**WEST SUSSEX COUNTY COUNCIL
PLANNING SERVICES CONSULTATION**

DATE: 16th November 2017

SUBJECT: LU/278/17/RES - Approval of Reserved Matters following Outline Permission LU/47/11 for Construction of the southern section of the Lyminster Bypass, including northern and southern roundabouts, surface water drainage and landscaping. Departure from the Development Plan & affects a Public Right of Way.

LOCATION: North Littlehampton Strategic Development Site, Land West of Toddington Park, Toddington Lane, Littlehampton, BN17 7PP.

35944/3501/004

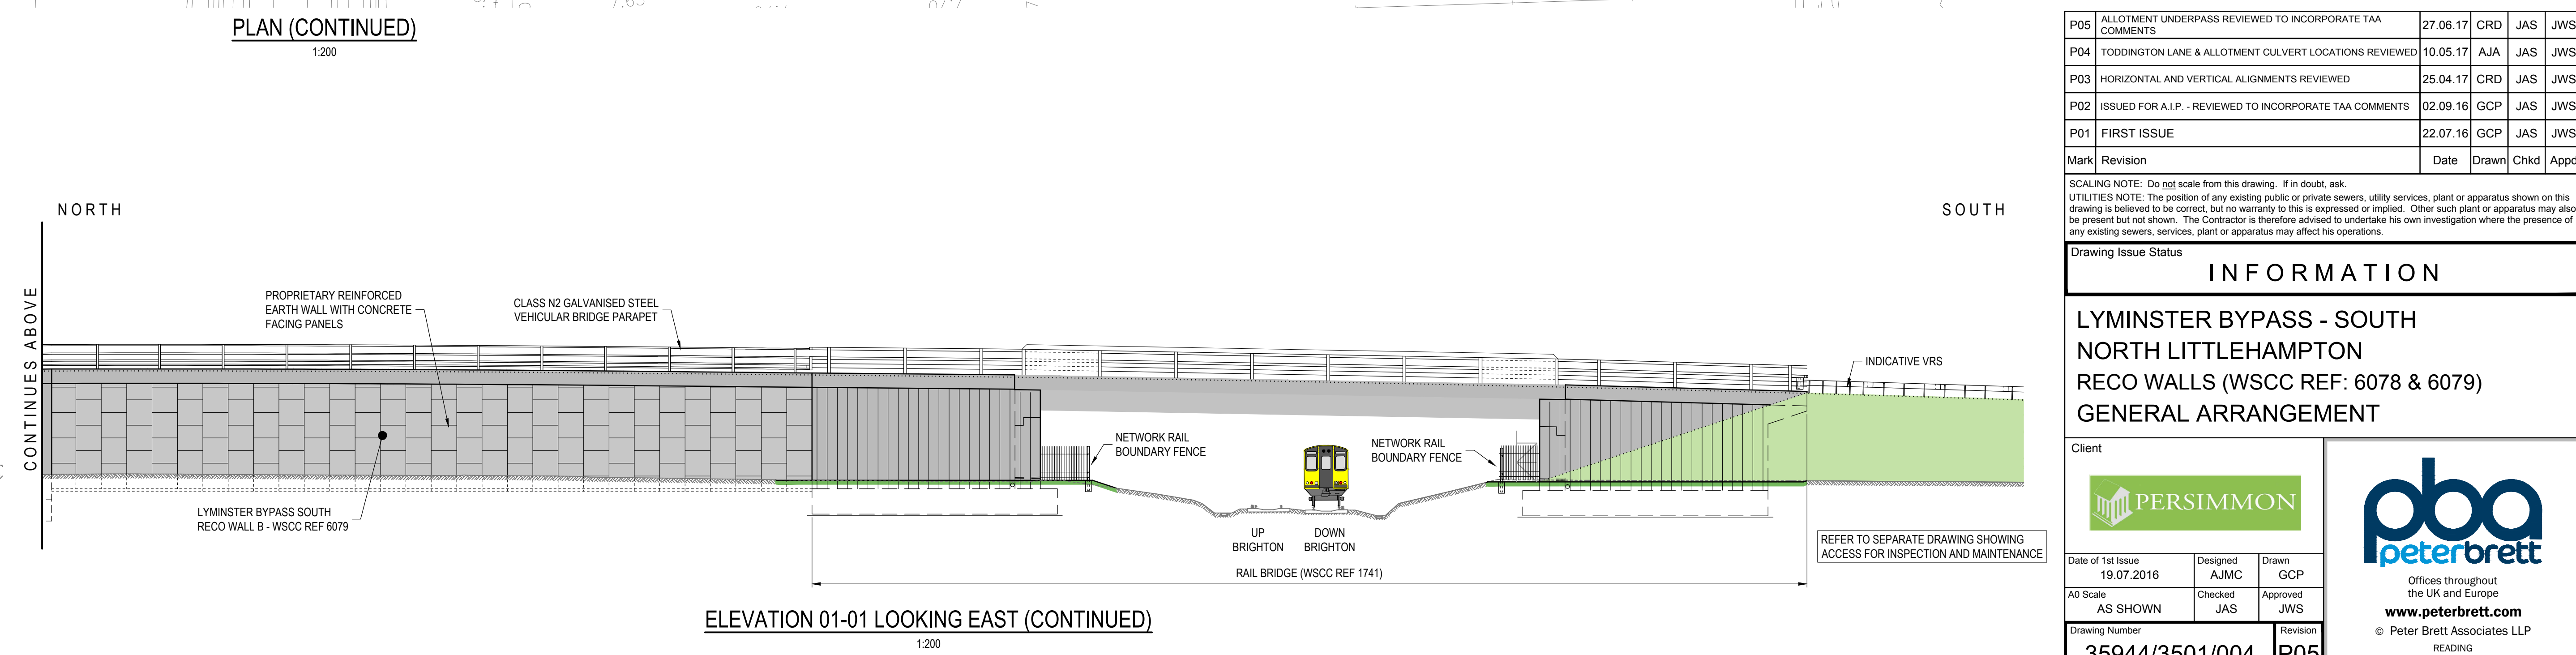
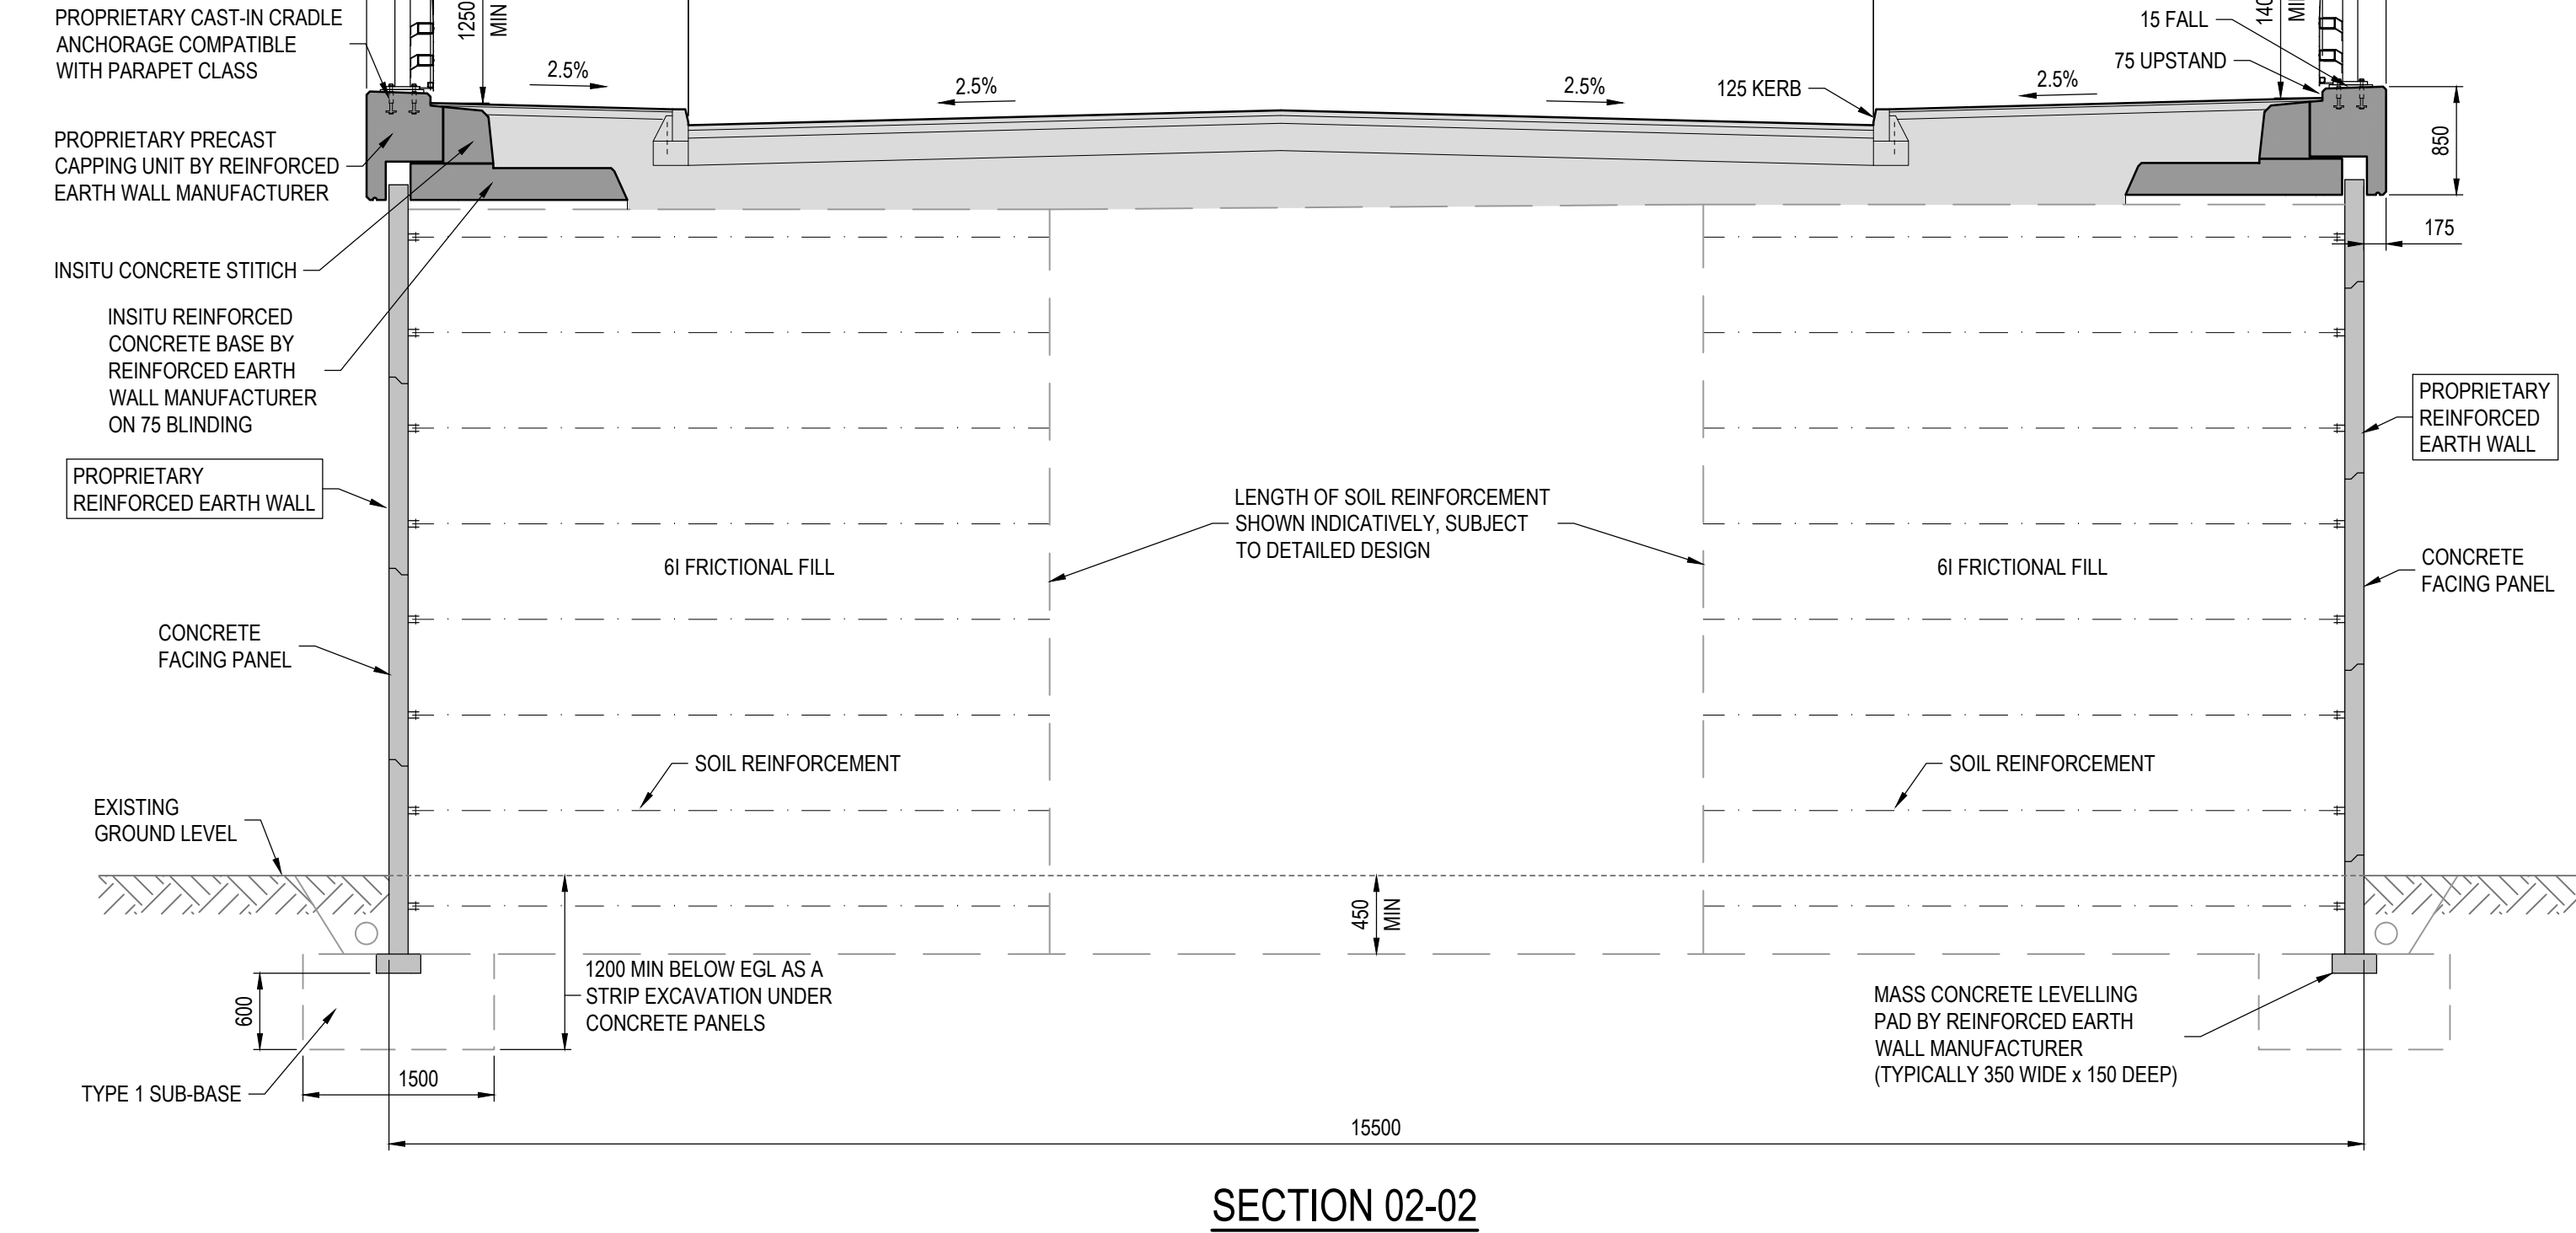
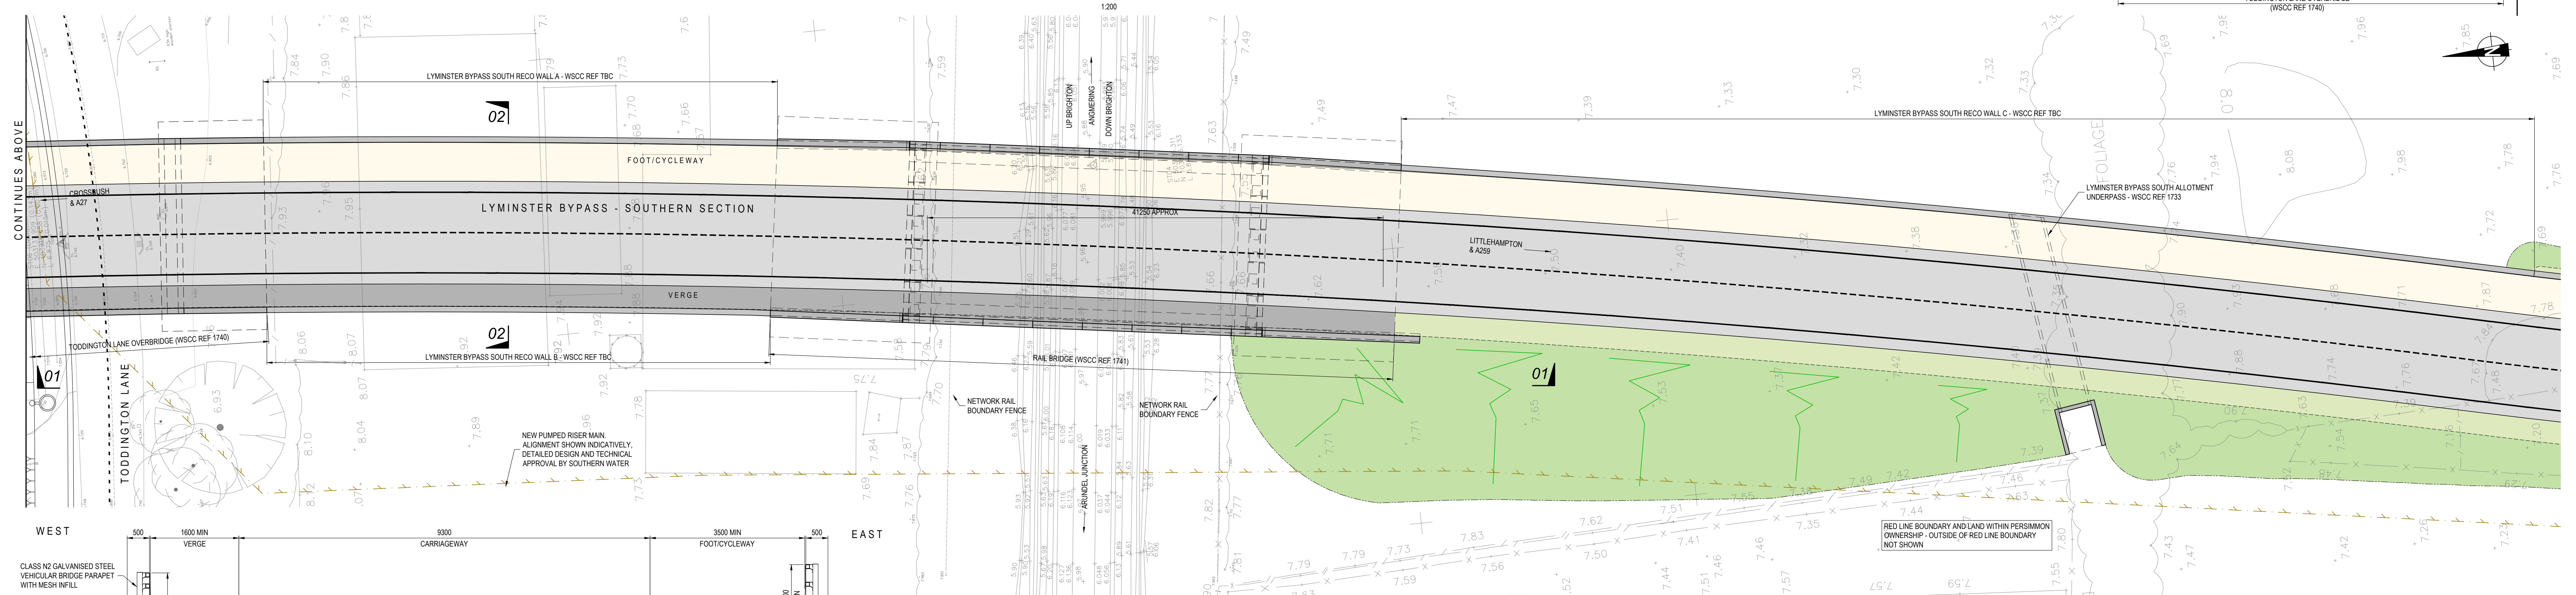
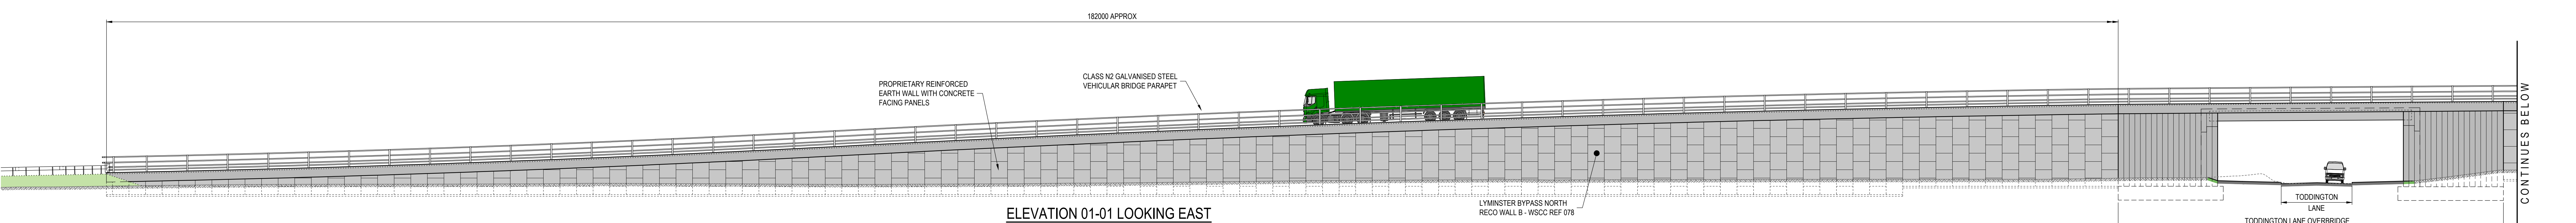
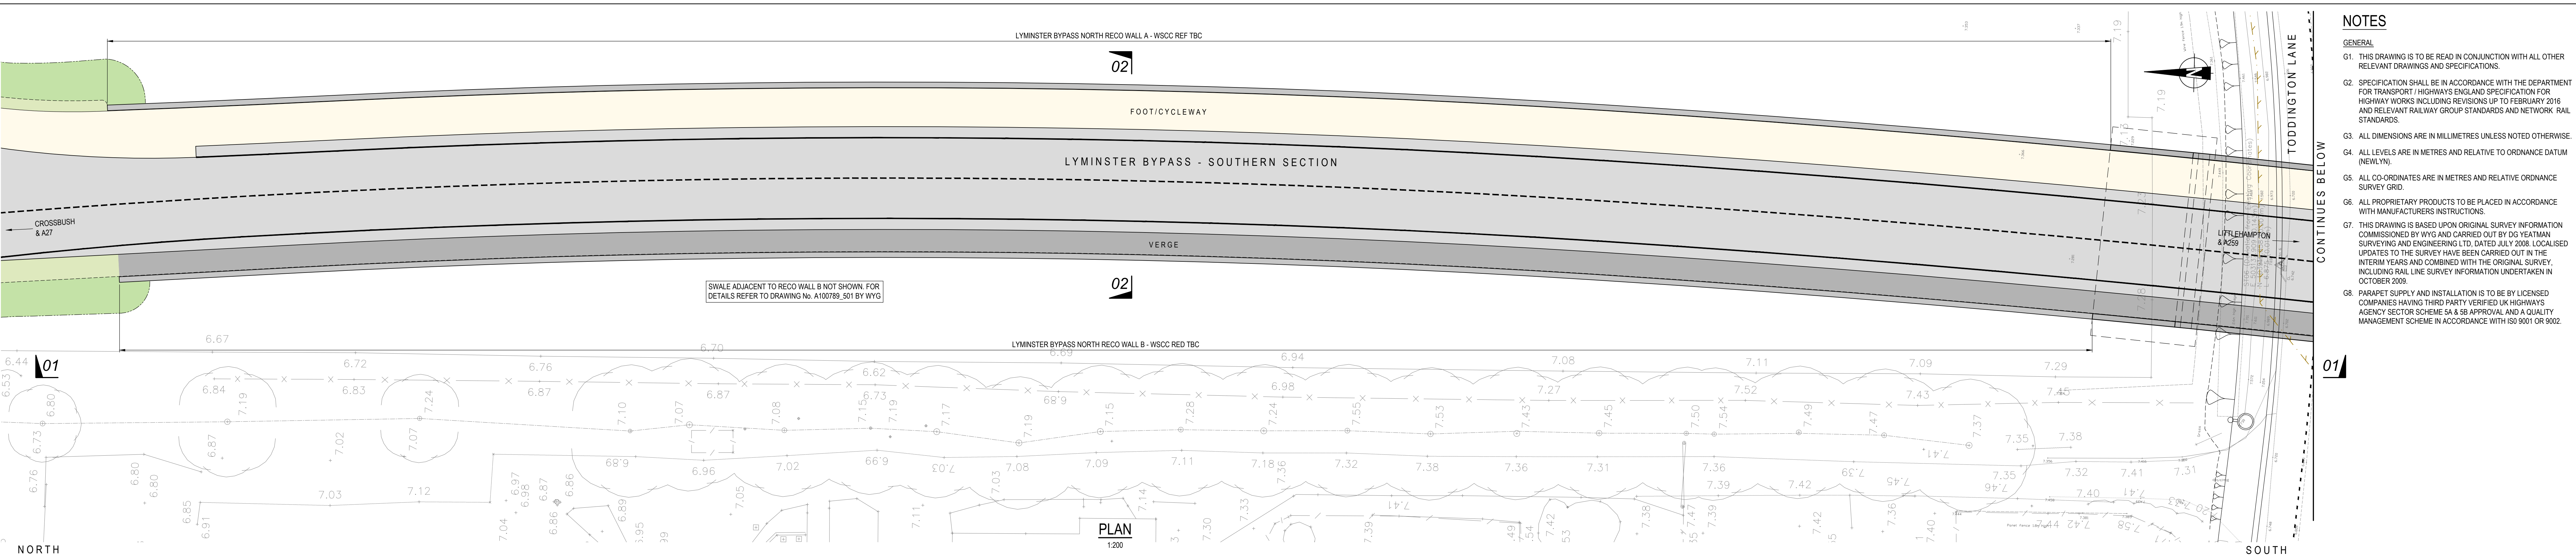
- AIP (bridge structures) – This is an ongoing process. WSCC's Structural Engineer has looked at the drawings on the Arun DC planning portal and the only one showing the bridges is Drg. No. 35944/3501/004 Rev P05. The current version of the same drawing that is on record here at WSCC that has been examined through the structures Technical Approval (TA) process is now Rev 6. At this stage, there do not appear to be any material changes that appear to affect the appearance when comparing drawing revisions. The Technical Approval process for the structures is, therefore, progressing and will continue to do so through the S38/278 stage.
